Your Ref: OWPC14653
Our Ref: BR/194/17/PL 30-06-2017
Please ask for:
Richard Temple

Demolition of the existing Foreshore office & decommissioning of existing underground toilets. New purpose built unisex toilet block including urinals, baby changing facilities & accessible WC, plus a separate beach office with public information point & first aid facilities. All located on the existing seafront promenade.

Promenade Opposite Clarence Road The Esplanade Bognor Regis

North Elevation

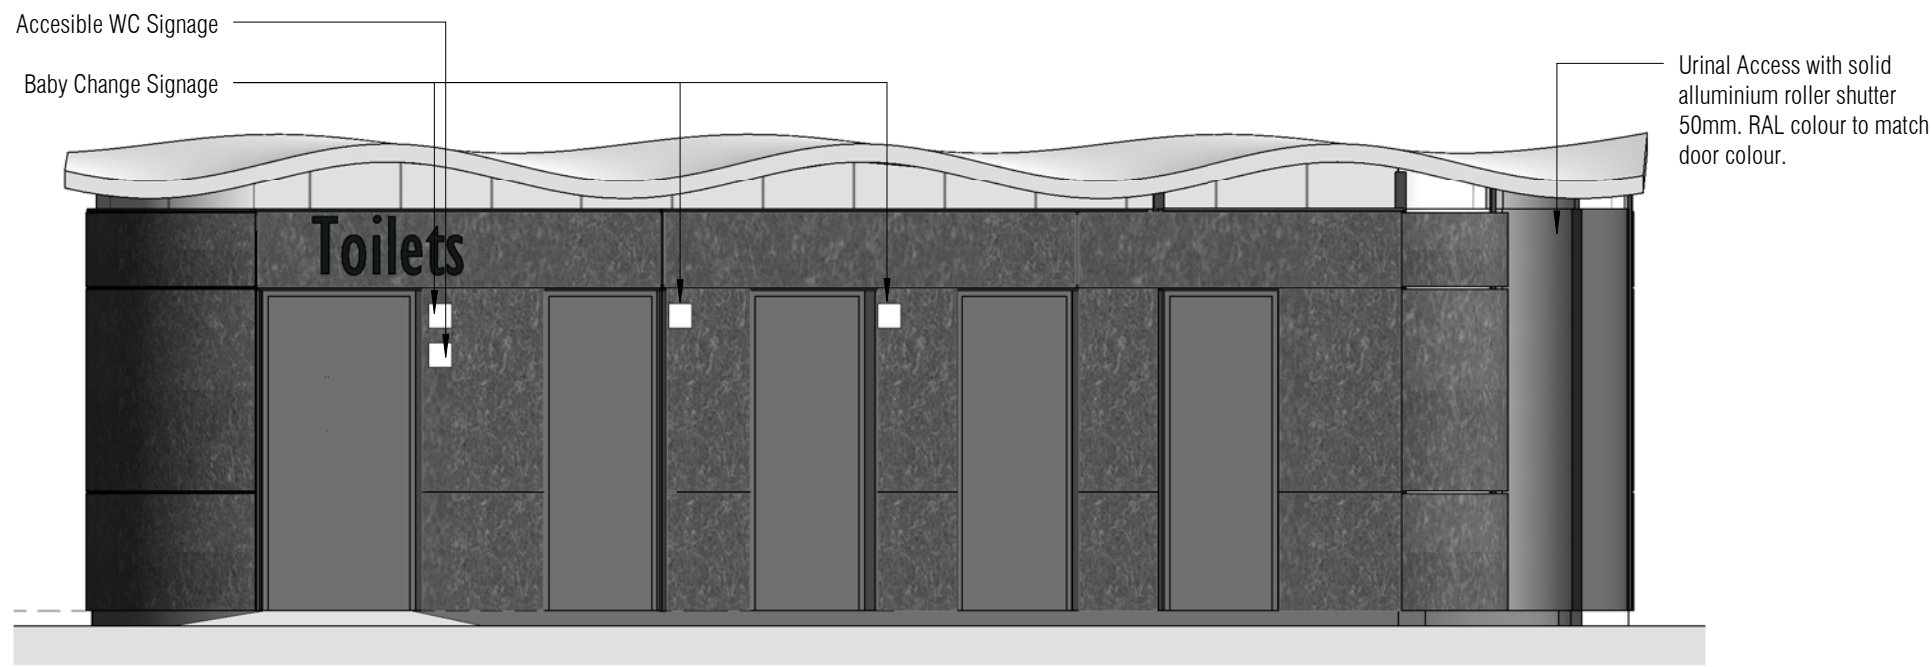
As for the placing of the WC cubicle doors on the north side, directly in the face of all the residents in the apartments opposite - this is beyond belief. No regard whatsoever for 'residential visual amenity'. A master stroke of bad taste by ADC!!
